Planning reference: 3/2024/0996

Location : 98 Ribchester Road and land adjacent 94 Ribchester Road, Clayton-Le-Dale, BB1 9HQ

Proposal : Approval of details reserved by conditions 9 (SW drainage), 12 (drainage scheme)

I refer to the letter from United Utilities dated 14th April 2025 in which United Utilities recommends that conditions 9 and 12 are not discharged. Two reasons were provided and these are below with our responses alongside.

EXISTING DRAINAGE

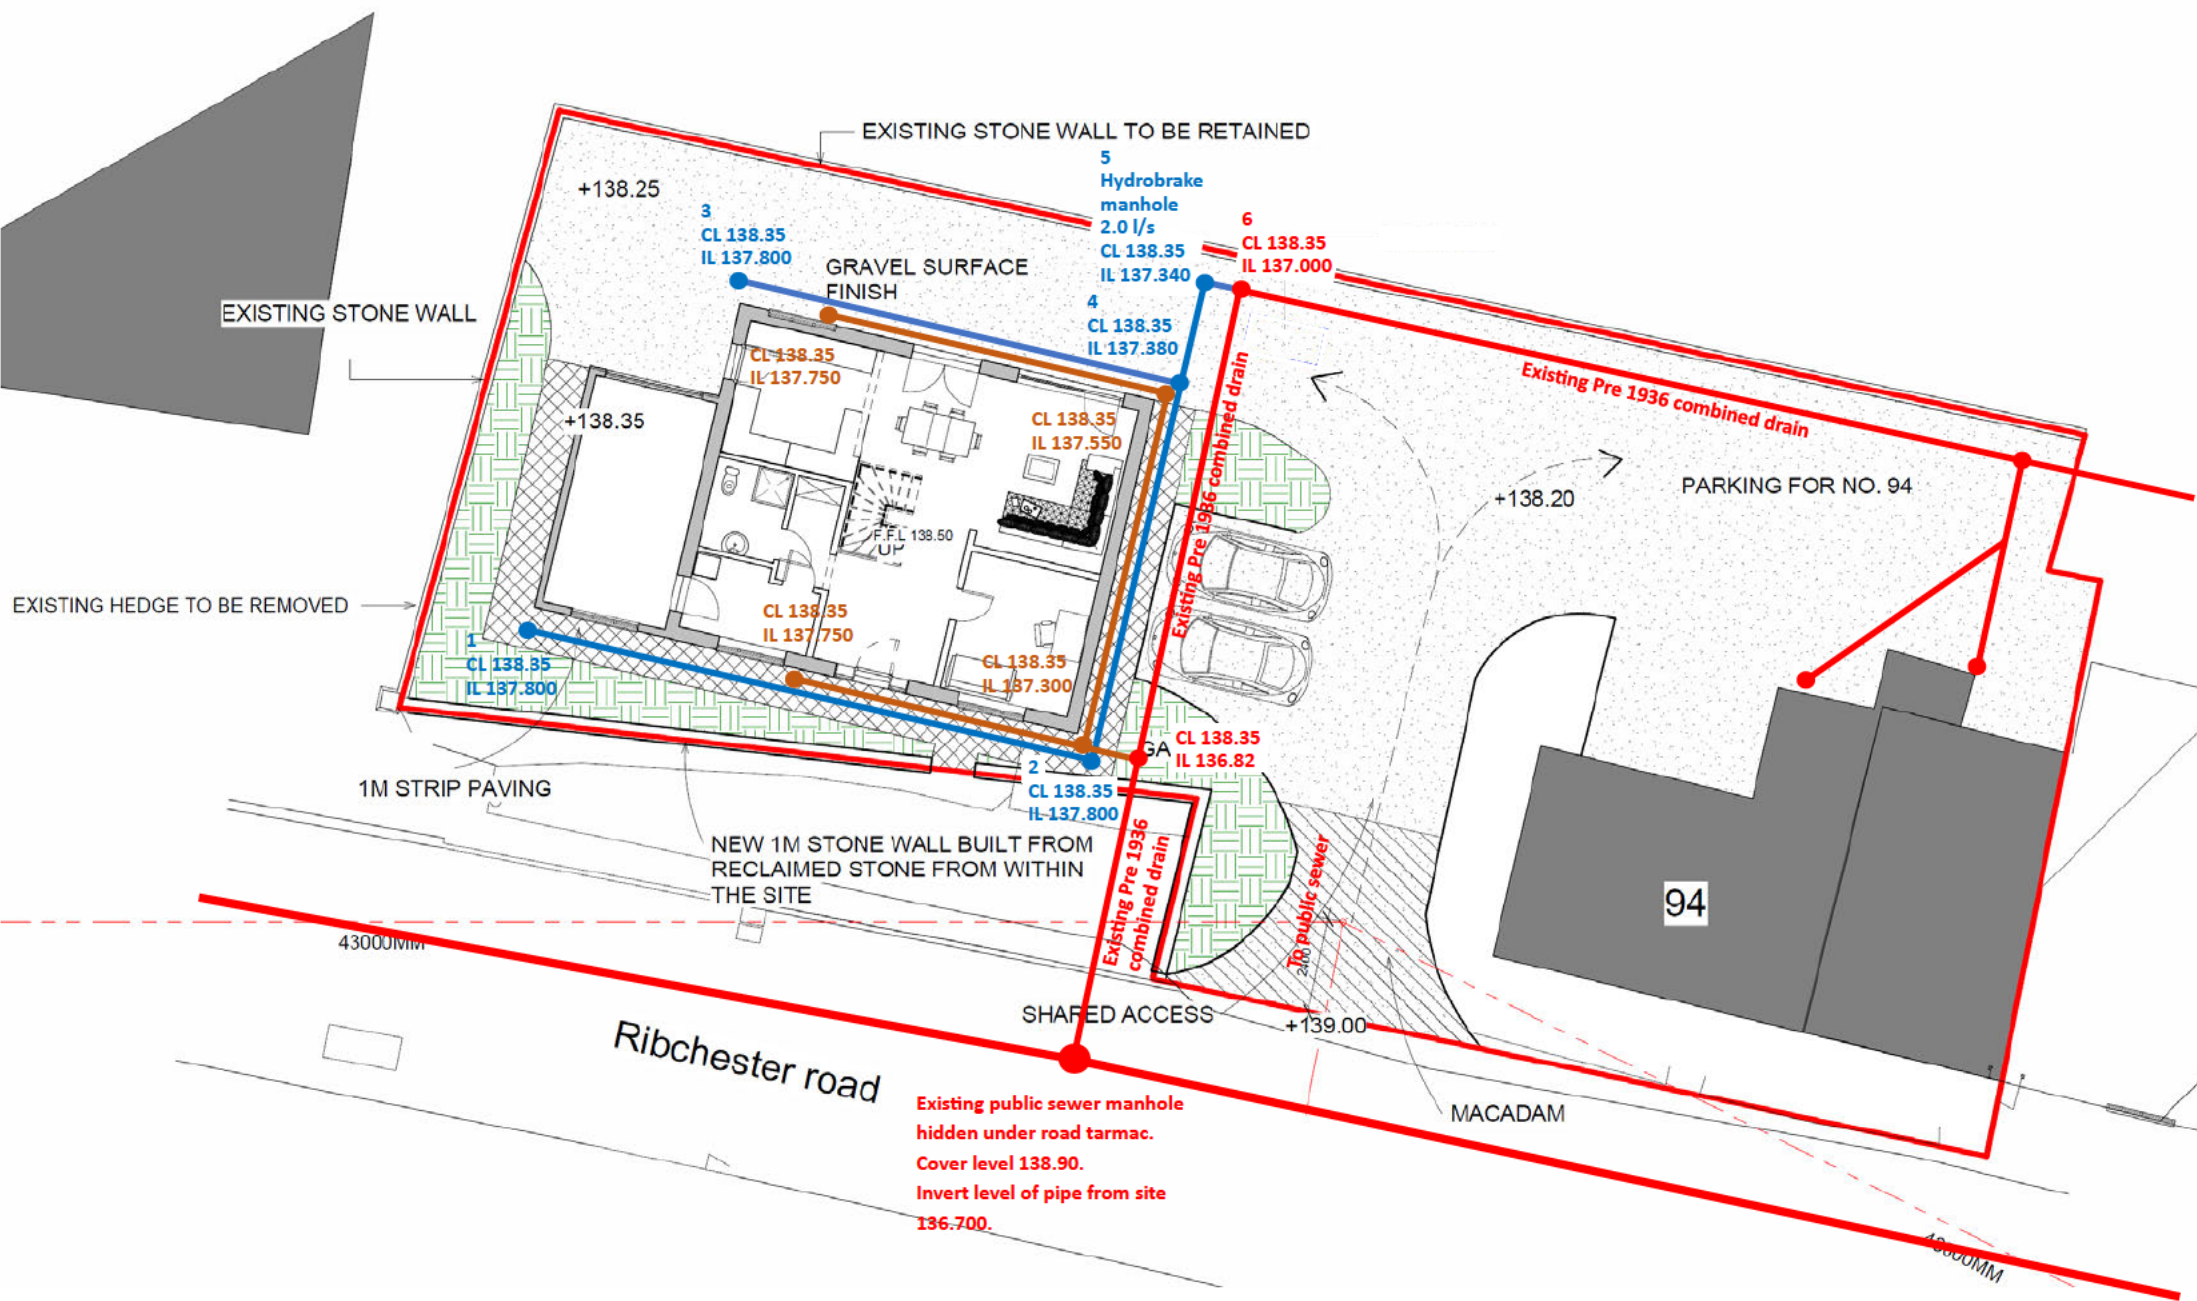
2. The sewer shown on our records is being assumed to be a combined sewer. The asset maps indicate it is a foul only sewer. We require evidence i.e. a drainage survey, to confirm that the foul sewer we have on our records is in fact a public combined sewer.

Response: A drainage survey has been carried out of the drainage within and beyond the application site. The result of the survey is shown on the existing drainage plan attached to this letter.

The drainage within the site extends beyond the site to the east of the site and serves the properties to the east that front onto the northern side of Ribchester Road. Dye testing has been carried out on the gullies taking rainwater from the roofs to the rear of the properties and it has been proved that the drain running along the rear of the existing properties takes both surface and foul water from the existing properties.

As stated above in response to item 1 above, it has been proved that this drain, leaving the development site under the existing access, is connected to the public sewer that lies within Ribchester Road into an existing manhole that is hidden under the road surfacing. As such, the public sewer within Ribchester Road is actually a combined sewer as it is taking both surface water and foul water from the existing properties that lie along the northern side of Ribchester Road. Therefore, under the hierarchy for dealing with surface water runoff from development sites, it is acceptable for surface water runoff to be discharged into it.

PROPOSED DRAINAGE LAYOUT

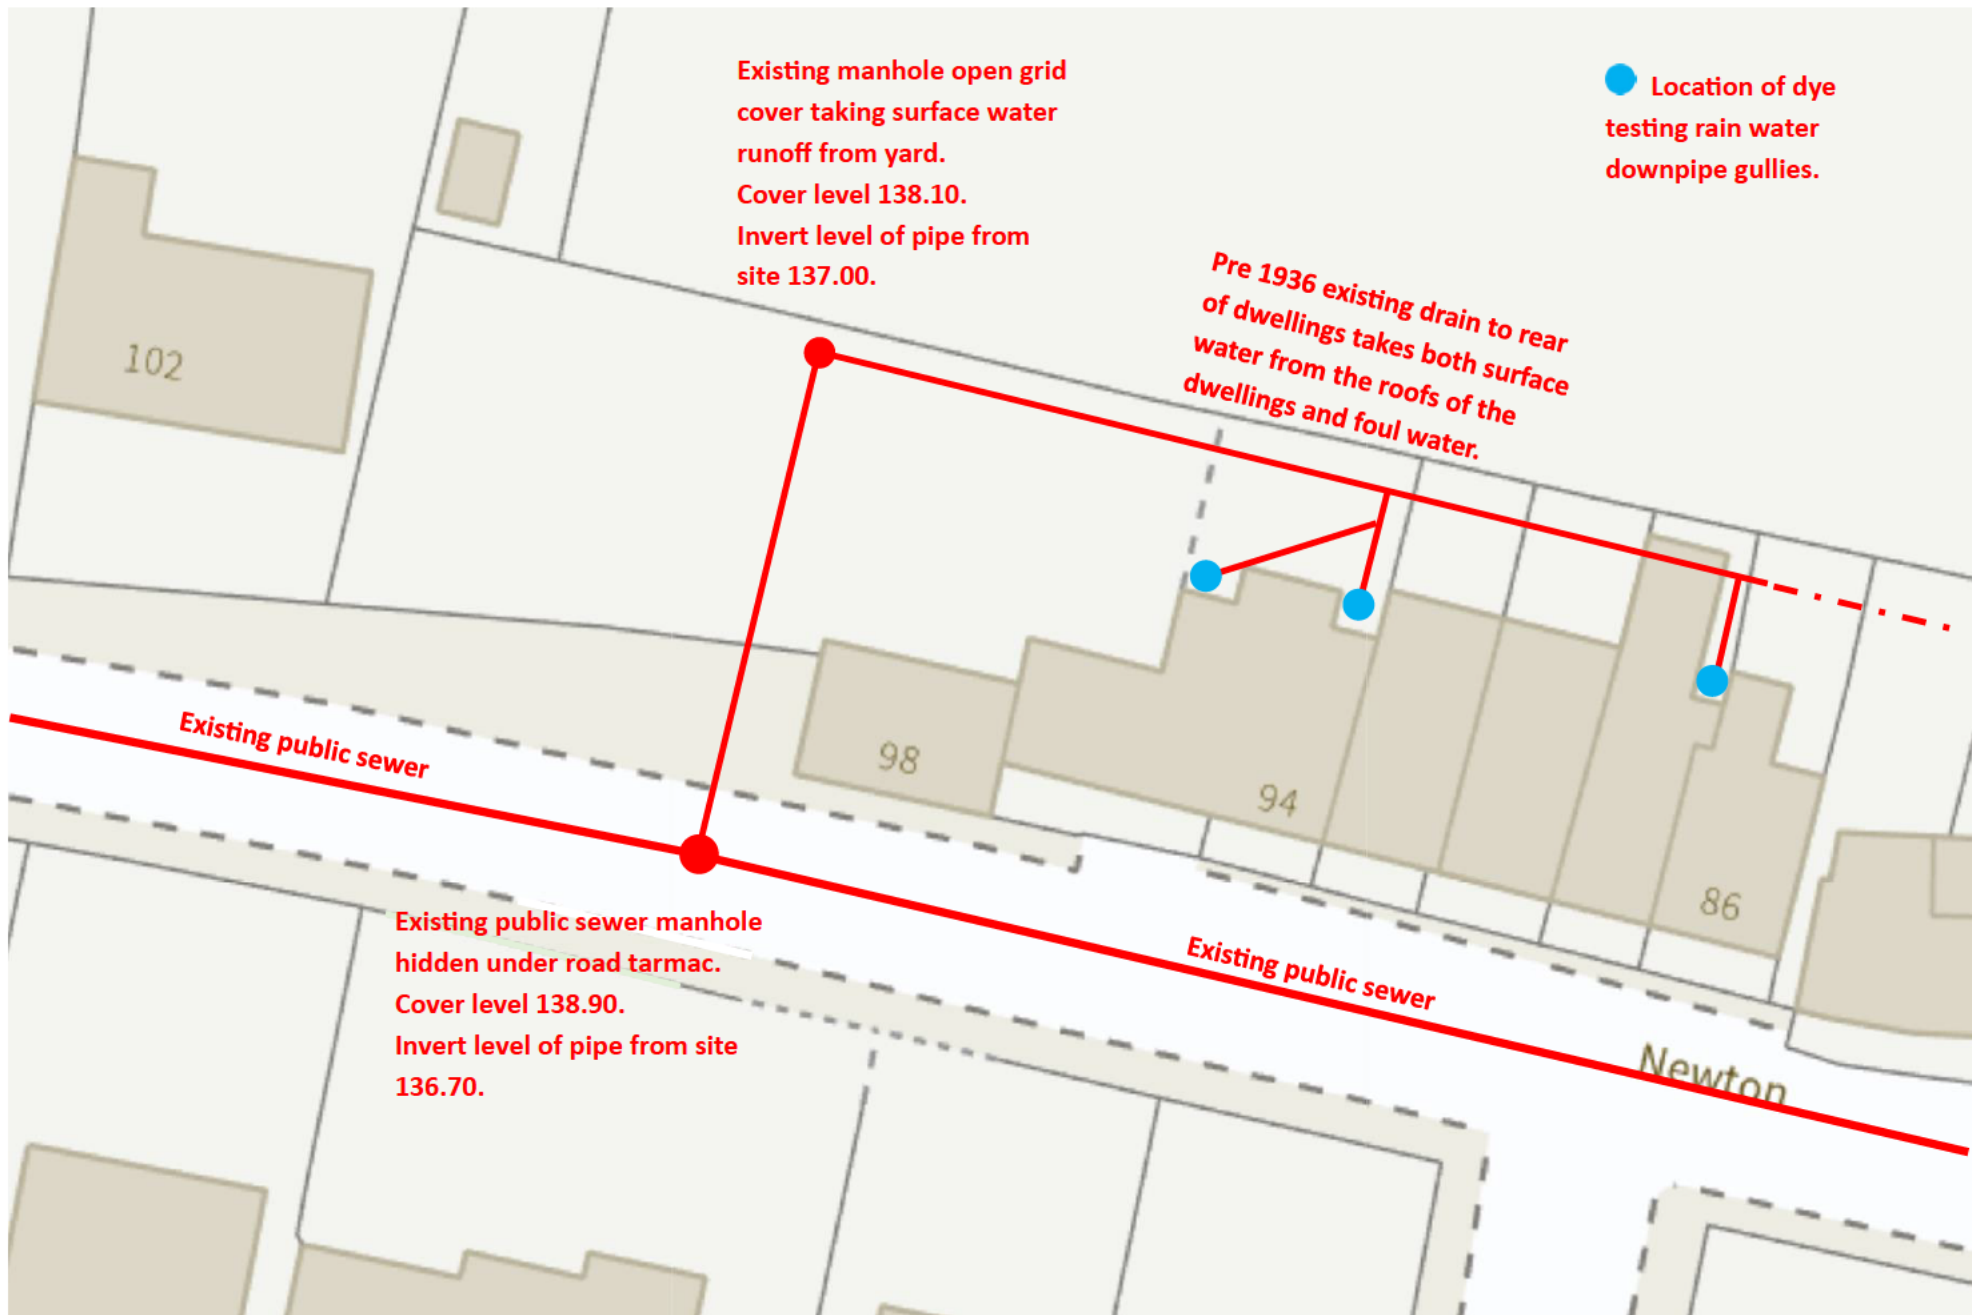
1. It is unclear how the connection is being made with the public wastewater network. We require a detailed drainage plan; clearly demonstrating how the scheme would connect to the public sewer. Noting that this is an application to discharge drainage conditions, we would expect the invert levels and cover levels to be included on the drainage plan.

Response: The drainage plan that was included within the surface and foul water drainage scheme report that was produced in support of the application to discharge the drainage conditions has been revised to provide the information requested above and is attached to this letter.

A drainage survey has been carried out on the drainage within and immediately beyond the development site. It has been proved that the drain leaving the development site under the existing access is connected to the public sewer that lies within Ribchester Road into an

existing manhole that is hidden under the road surfacing. The existing connection enables discharges to be made from the existing site and will be used to enable discharges from the proposed development.
